## Portishead Branch Line (MetroWest Phase 1)

9.59 ExA.CWR.D7.V1 – Applicant's response to Written Representations submitted for Deadline 6

## Applicant's Responses to submissions received at Deadline 6

LODWAY FARM

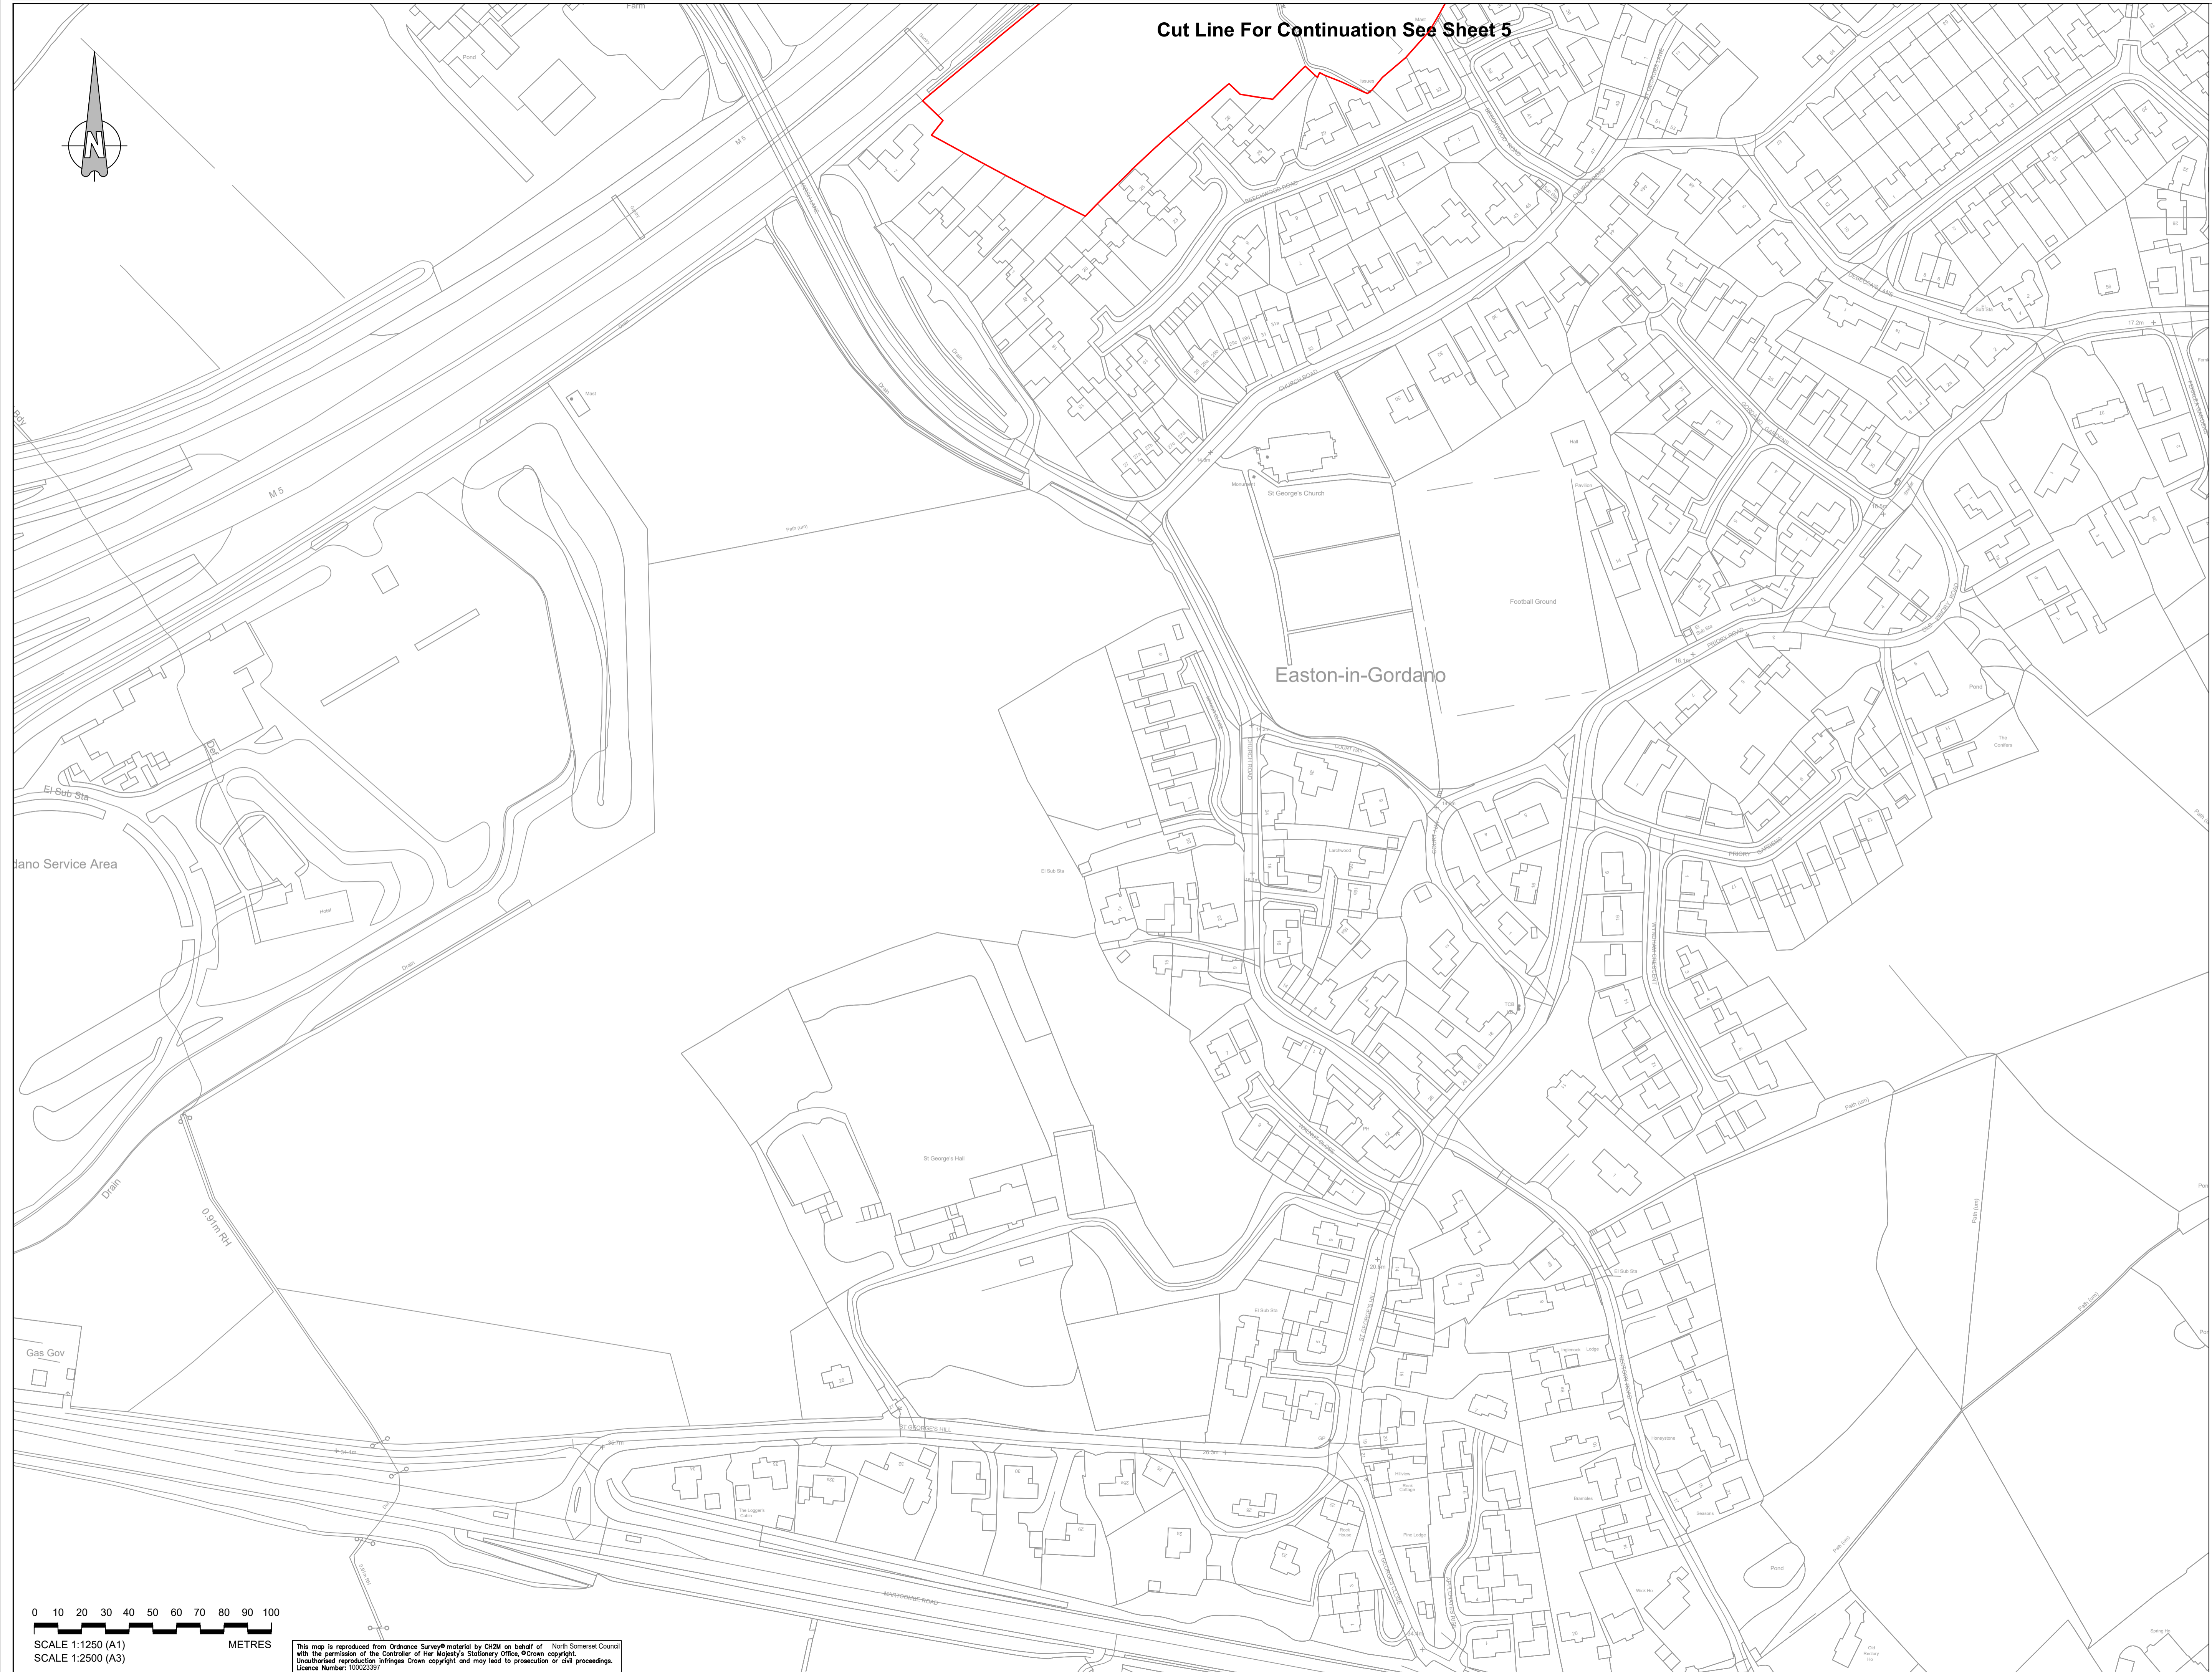
001296 -D6- 002			a. The load-bearing surface to be strong enough and durable enough to sustain intensive movements of heavily laden vehicles for a period of up to two years. If the haul road had to be closed for repairs for more than a day or two during the construction phase this would inevitably place huge pressure on the contractors to divert HGV traffic to The Breaches access to Lodway Farm.	The points raised by Mr Ovel and Mr Berry regarding Bristol Port's perimeter access track and the use of HGV's in Pill were dealt with by the Applicant in point 32 to 35 of Doc 9.41 Applicants Oral Case and Response at ISH5 (DCO document ref. 9.41 ExA.ISH5.D6.V1).  The section of the Breaches closest to Church Road and Debeccas Lane will not be used for HGVs.
001296 -D6- 003			b. The haul road to be widened wherever possible to enable two HGVs to pass one another. It is our contention that this is essential in order to make the haul road route viable for multiple inbound and outbound journeys to/from the Lodway Farm Compound. Otherwise, it can be envisioned that a one-way system might be instituted using The Breaches to ingress Lodway Farm and the haul road for outbound traffic in order to maintain traffic flow through the compound. This should be specifically ruled out in the DCO, as it would place an unacceptable burden on the surrounding roads.	The points raised by Mr Ovel and Mr Berry regarding Bristol Port's perimeter access track and the use of HGV's in Pill were dealt with by the Applicant in point 32 to 35 of Doc 9.41 Applicants Oral Case and Response at ISH5 (DCO document ref. 9.41 ExA.ISH5.D6.V1).  Priory Road will be used by HGV's to access the secondary access to Lodway compound, particularly in

No.	Type / Category	Response topic	Response	Applicant's response
			Mr Willcock stated that water features adjacent to the haul road preclude this. There are, indeed, short sections of the haul road where that might be the case but from personal observation I believe that there is space for the great majority of the road to be widened to two-lane width to enable vehicles to pass safely. The underlying objection from MetroWest to making the haul road fit for purpose appeared to be one of cost. We recognise that cost control is very important but contend that not to upgrade the haul road prior to the start of the construction phase would be a false economy. Indeed it was conceded by Mr Willcock that the road would, in all probability, have to be repaired at the end of the construction phase, so money will have to be spent on it anyway.	the later stages of construction when the permanent works to rebuild the current dis-used line through the M5 railway underbridge have been completed and as a result there is no longer a through HGV route available to Lodway compound, via Marsh Lane. The applicant wishes to point out that this short section of narrow width of Priory Road (the main highway route through Easton-in-Gordano/Pill) is used every day by double deck buses and HGV's.  The section of the Breaches closest to Church Road and Debeccas Lane will not be used for HGVs.

001296 -D6- 004			2. With regard to my comments at the Hearing about the possible railway siding into the Lodway Farm Compound mentioned in the DCO, it is clear that a viable haul road capable of sustaining two-way traffic will be required anyway. Provided that MetroWest project HGV's are kept away from the village road structure, it is not of direct concern to us whether the materials are transported to/from the Lodway Farm Compound via the haul road or by rail.	The points raised by Mr Ovel and Mr Berry regarding Bristol Port's perimeter access track and the use of HGV's in Pill were dealt with by the Applicant in point 32 to 35 of Doc 9.41 Applicants Oral Case and Response at ISH5 (DCO document ref. 9.41 ExA.ISH5.D6.V1).
			Intuitively, it seems that a dedicated railway siding would be the better option for the local environment. However, it was clear from the comments made by Mr Willcock and, I think, Mr Willmot that, for a variety of reasons, this would not be a practicable solution. The appearance of the railway siding option in the DCO is therefore something of a red herring. This again, reinforces the necessity of ensuring that the haul road is improved to make it fit for purpose from the outset.	Priory Road will be used by HGV's to access the secondary access to Lodway compound, particularly in the later stages of construction when the permanent works to rebuild the current dis-used line through the M5 railway underbridge have been completed and as a result there is no longer a through HGV route available to Lodway compound, via Marsh Lane.

001296 -D6- 005			3. I became aware during the course of the Hearing of a new factor potentially affecting the haul road when it emerged that the direction of laying of the new track laying would now be to the west commencing from the Pill end. On the DCO 2.4 General Arrangement Plan the haul road is shown as running through the	It is not possible to construct the scheme without some HGV's being routed via Priory Road. Given the scheme cannot be constructed without Lodway compound. It provides the required lay down area for the new railway bridge over the path between Avon
